GORT PUBLIC REALM ENHANCEMENT PROJECT

AN COIMISIUN PLEANALA CASE NO. 323066-25

**GALWAY COUNTY COUNCIL RESPONSE TO
OBSERVATION BY:**

J. RICKS

PROJECT TITLE	GORT TOWN CENTRE		
PROJECT NUMBER	P3003160		
DRAWN BY	LANDSCAPE GENERAL	SCALE	@ A1
CHECKED BY	ARRANGEMENT	DATE	1:200
DATE	SHEET 6 OF 9	REVISION	16.08.23
PROJECT NUMBER	3160-BDP-00-XX-DR-L-0106	REVISION	P05

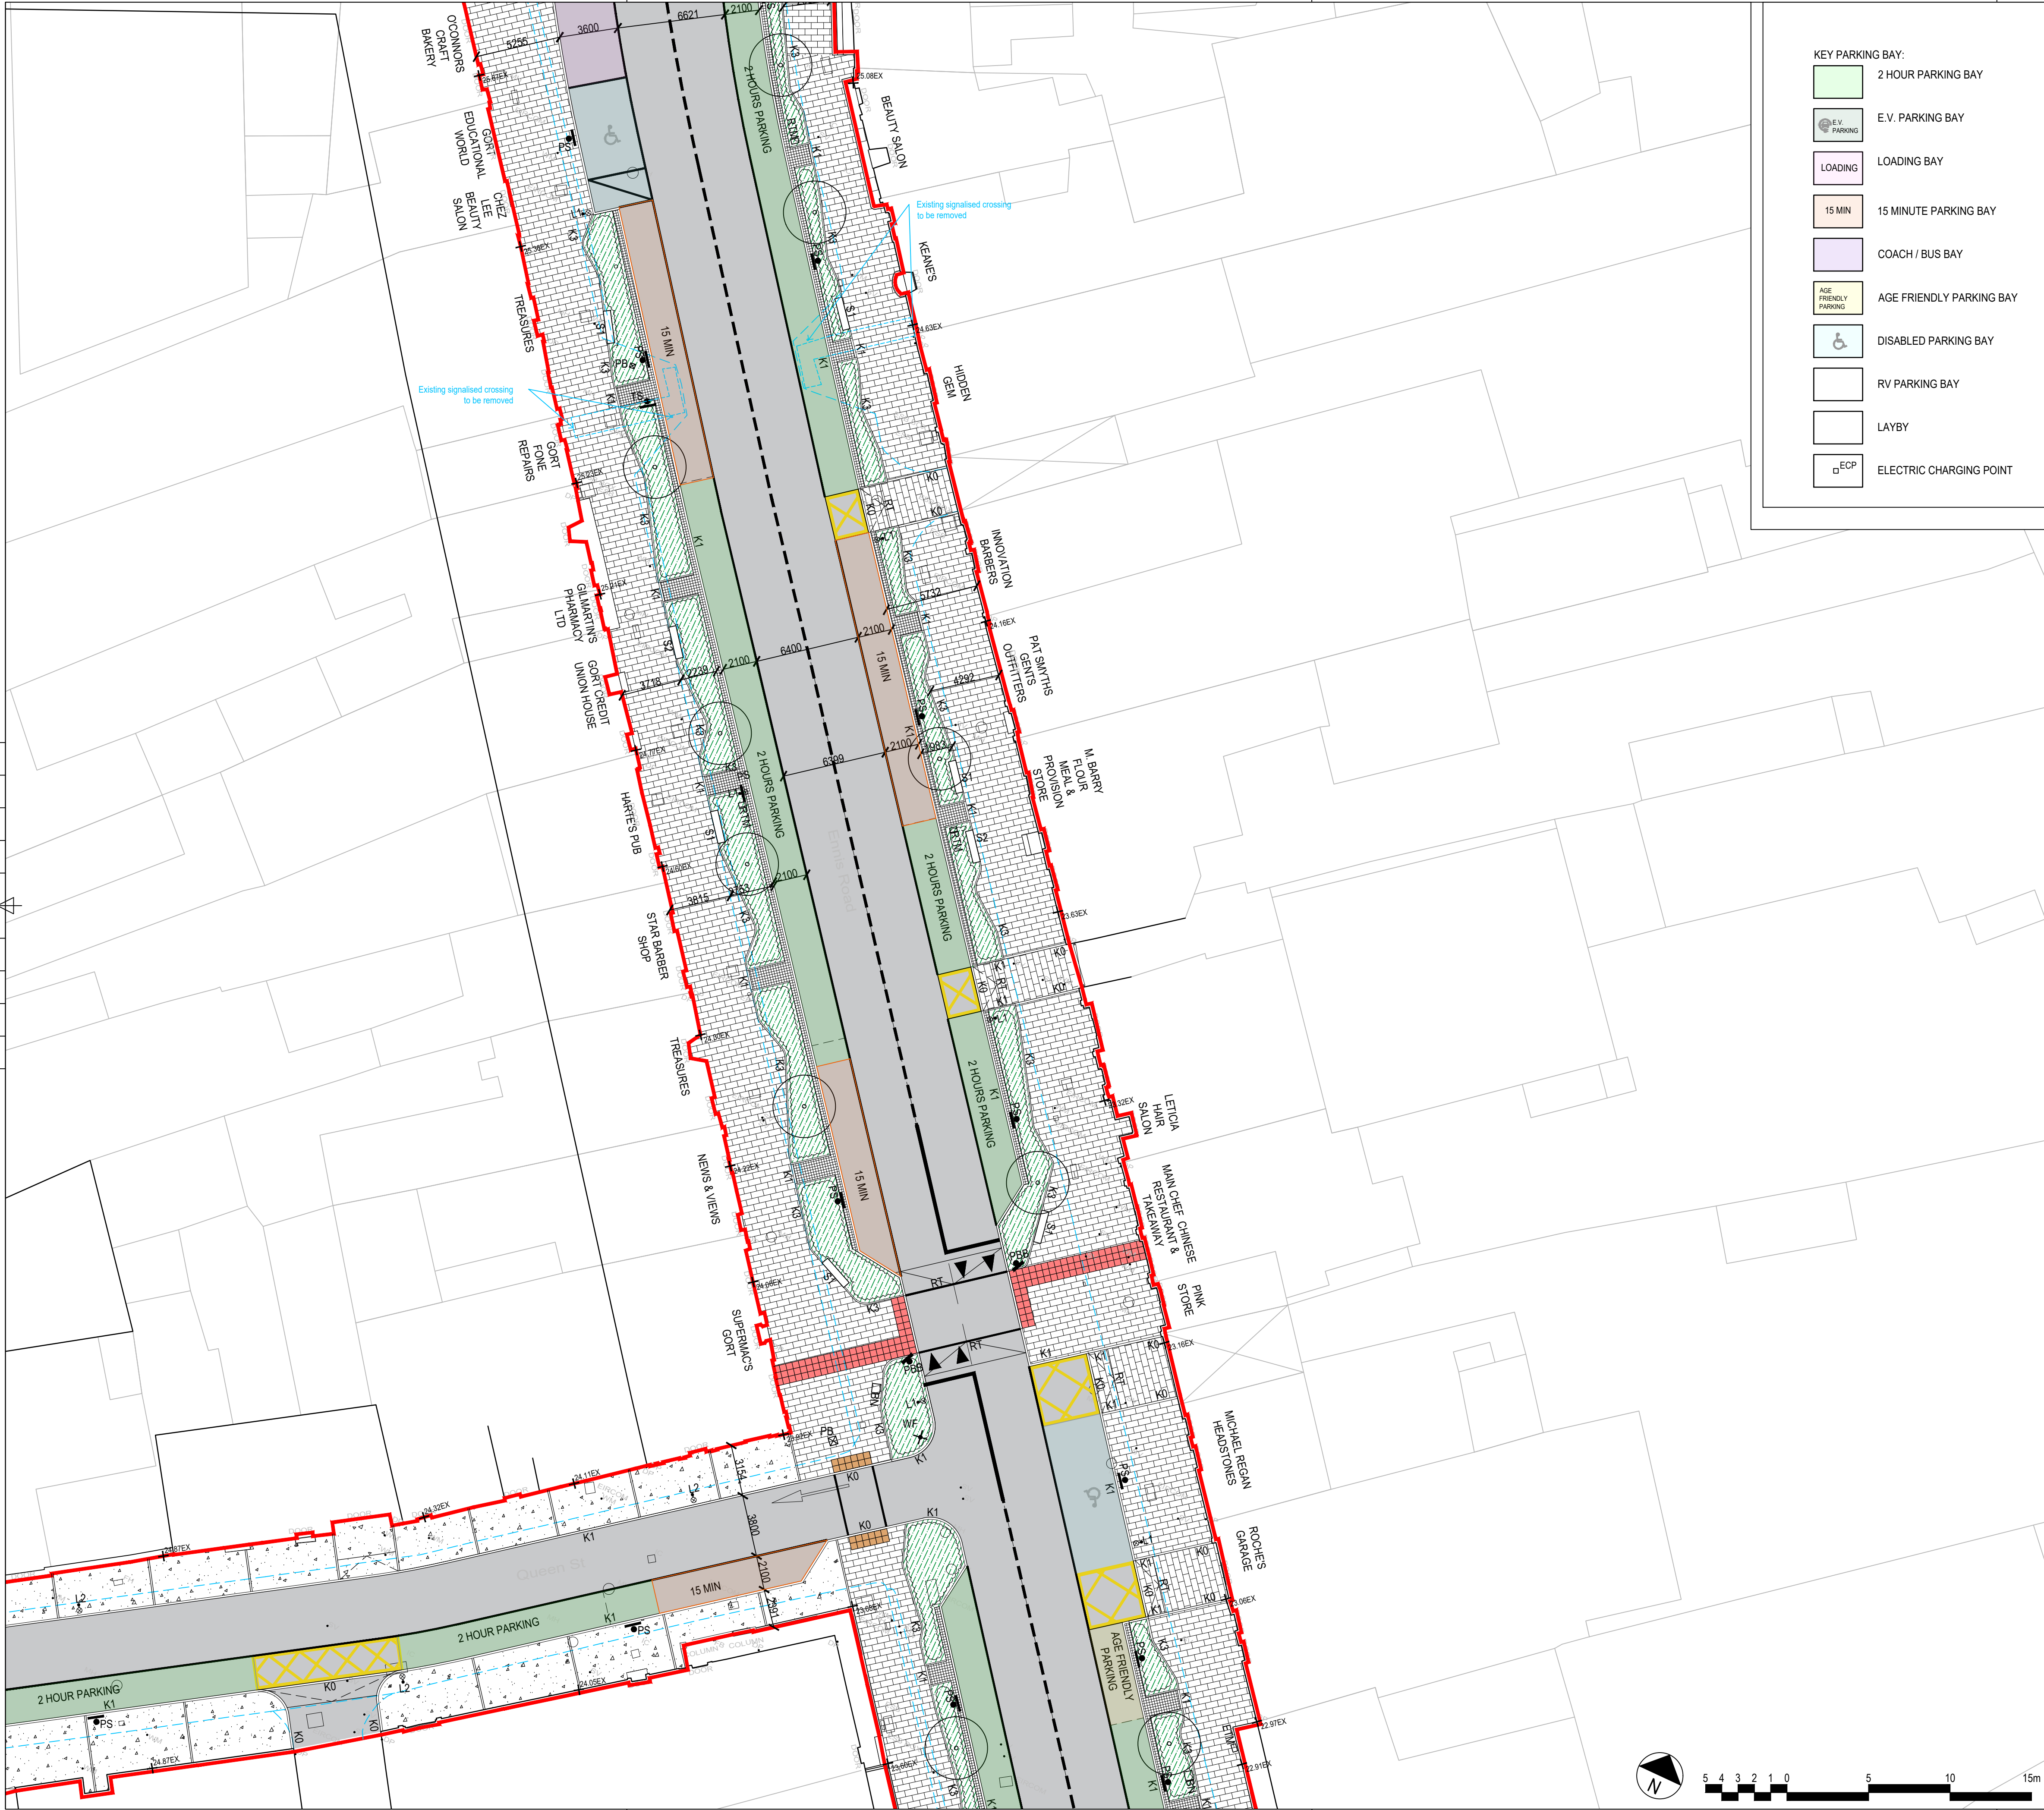
At present the footpath outside of the M. Barry building is 3500mm wide. As part of the proposed public realm enhancement project (should planning permission be granted) the clear footpath width will be increased to approximately 4292mm with an overall width of 5732mm. This increase is to be implemented in support of the aims and objectives described in the Galway Development Plan and supporting statutory and non-statutory documents.

Image 1: Extract from drawing number DR-L-0106 showing the proposed clear footpath width of 4292mm with an overall width of 5732mm. The tree is located to the north of the premises in question and will therefore not obstruct natural light.

It should be noted that the proposed tree location lies to the north of the M. Barry building and therefore no significant loss of natural daylight into the premises is anticipated.
